### Building Code of Australia (BCA) Preliminary Review

PROJECT REF.	170087
Project Details	Inner Sydney High School (ISHS) Corner of Cleveland and Chalmers Street, Surry Hills NSW 2010
Development Proposal	Internal reconfiguration of existing heritage listed building & construction of a new fourteen (14) storey multi-purpose school building including rooftop play area (approximately 56.5m from park level).
Client	NSW Department of Education C/- FJMT
Date	06 June 2017 (Rev C)

Proposed Works	Description
Classification(s)	9b
Use	School (Assembly Building); <b>Entertainment Venue</b> (Determined by Clause 16.08 of EFSG for Basement and Lower Ground)
Rise in Storeys	Fourteen (14)
Levels Contained	Fifteen (15)
Type of Construction	Type A
Effective Height	More than 50m (50.5m) <i>Note: Effective height requirements synopsis;</i> - Provision of Fire Control Room - Provision of Hydrant Mid-Level Pumping station
Fire Compartment Sizes	TBC. Details of proposed Volume and Floor Areas are to be provided. <i>Note: BCA Deemed to Satisfy (DTS) limits the maximum compartment size to be less than ,8000m2 and 48,000m3 (Type A Building)</i>

title
**General Arrangement Plans
Basement Plan**

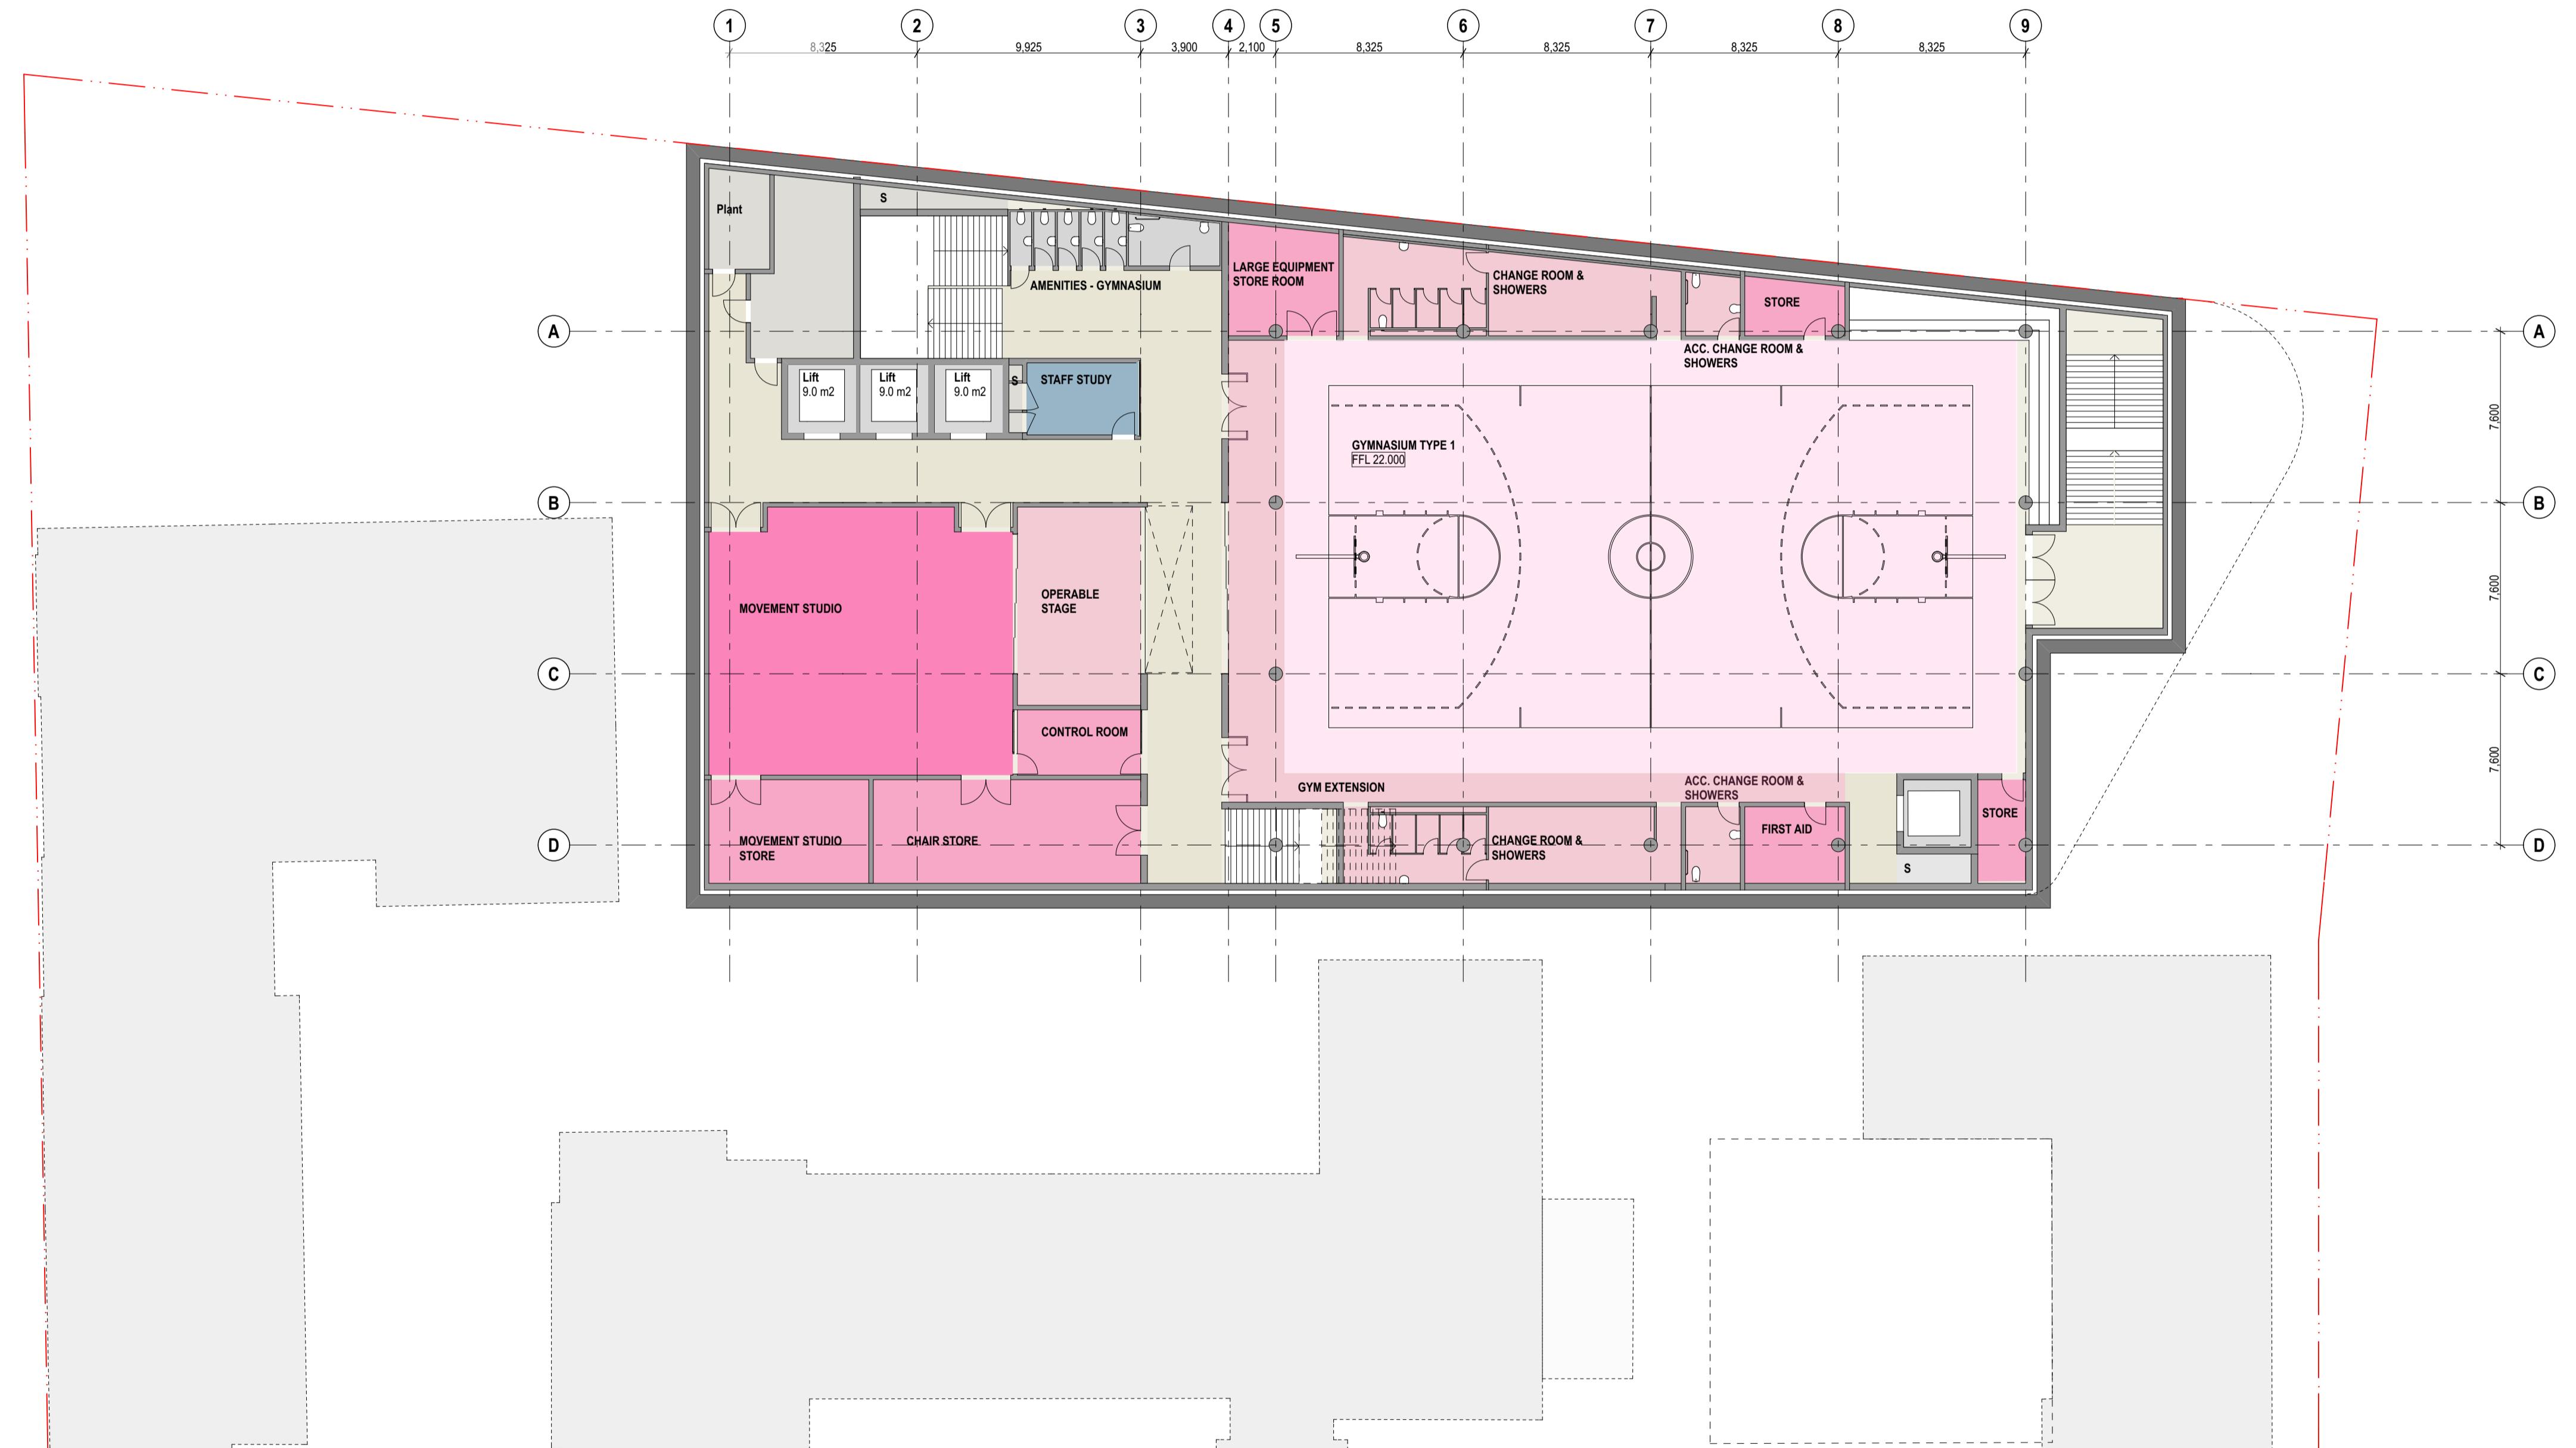
<b>D1.6</b>	The unobstructed width of each exit or path of travel to an exit (except at doorways) must be not less than 1,000mm for the basement and lower ground floor entertainment venues.

CLAUSE	Comments
16.08	<p>This Clause of the SFS requires that the entertainment venue provisions of the BCA be applied to any Gymnasium, Performance Studio or Communal Hall.</p> <p>Based on this the Basement and Lower Ground floors are to achieve compliance with the requirements of NSW Part H101 (Entertainment Venues) of the BCA.</p> <p>Which will include but not limited to:</p> <ul style="list-style-type: none"> <li>• Fire Separation of the Entertainment Venue from the rest of the building</li> <li>• Stages if they exceed 50m2 then Smoke Exhaust will be required over the stage – confirmation once design progresses to limit this will be required to ensure this provision is not needed, if this exceeds 150m2 then additional provisions applies.</li> <li>• Lighting Bar – needs to be confirmed as not being used for scenery or other props, if that occurs then additional requirements apply</li> <li>• Smoke Exhaust to the Entertainment Level – based on Clause 16.08 of SFS, the exemption under NSW Table E2.2b does not apply, which means that Automatic Smoke Exhaust will be required to the Gym, Movement Studio and Lower Ground Floor areas within the Entertainment Venue (5MW).</li> </ul>
